Application No: LU/149/20/PL
Site Address: Littlehampton Wave Sea Road Littlehampton BN16 2NA
Description of works: Installation of a 4m high timber sculpture shaped in the form of 3 No. waves, fixed to a concrete base. This application is not CIL Liable (Zero Rated) as 'all other development'.

Thank you for your internet representation made on 3rd July 2020 which has been recorded as an objection with the comments as follows:

OWPC28204

Drawing Title:
Plan & Elevation of Sculpture
Concrete Plinth

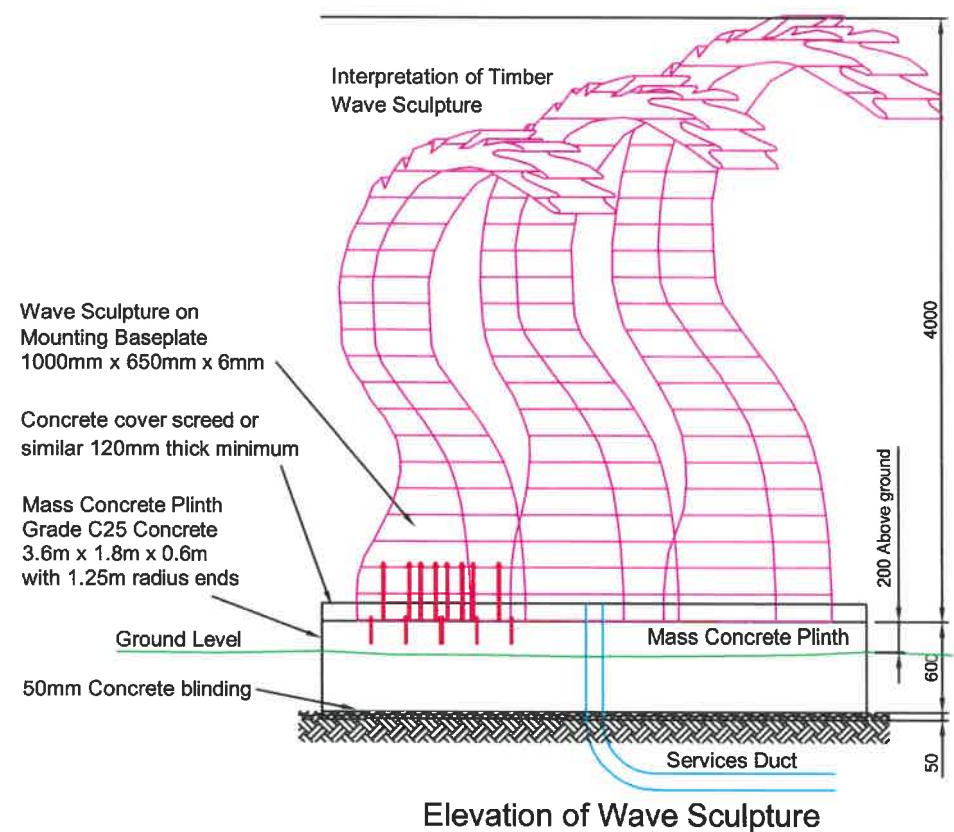
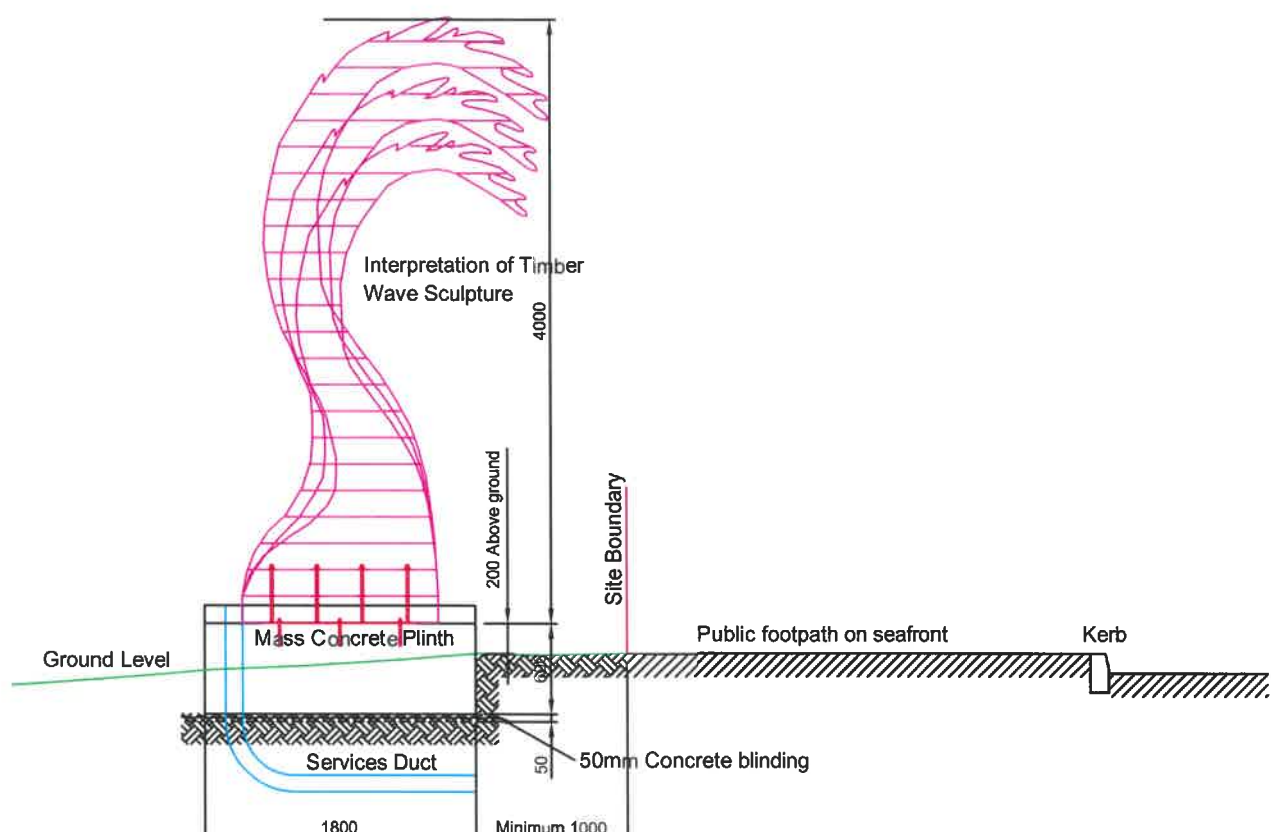
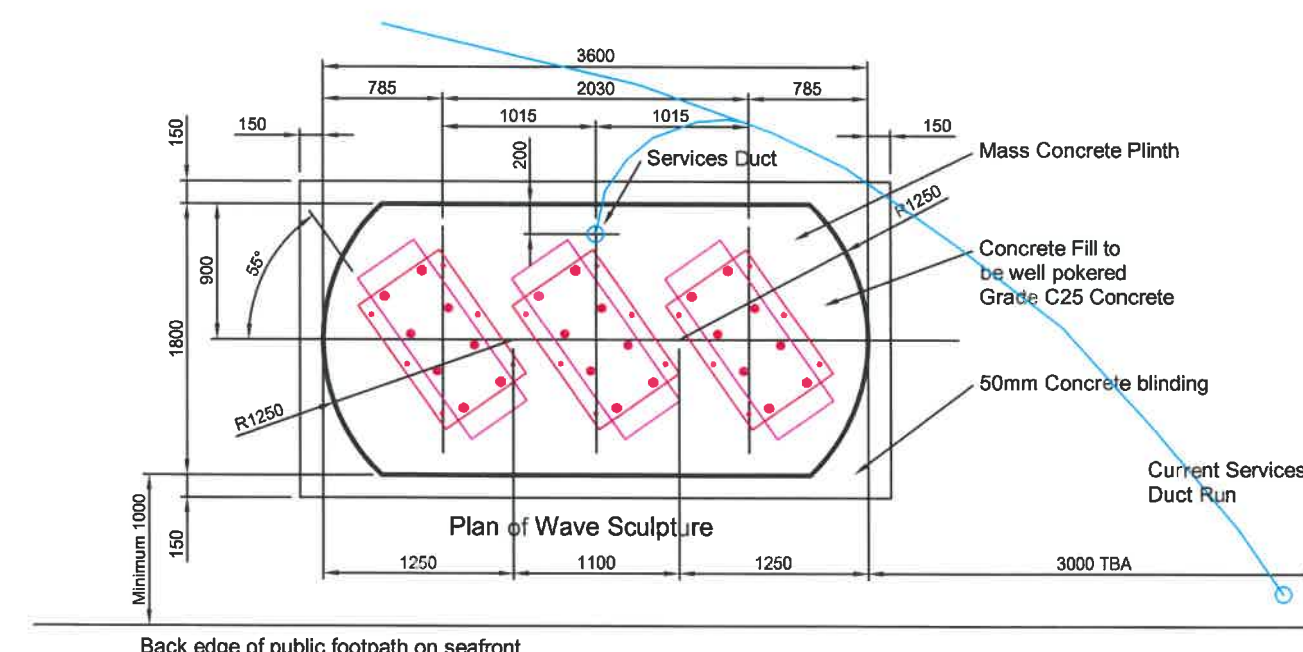
Public art should add value not worsen the view. The photo looks like 3 £ signs rather than waves. Waves are already a feature of our natural landscape and do not need replicating. I would suggest the landscaped area in front of the building is an appropriate vista fronting the new building and it does not need a sculpture at all. Certainly not one of such poor quality as suggested in the photo.
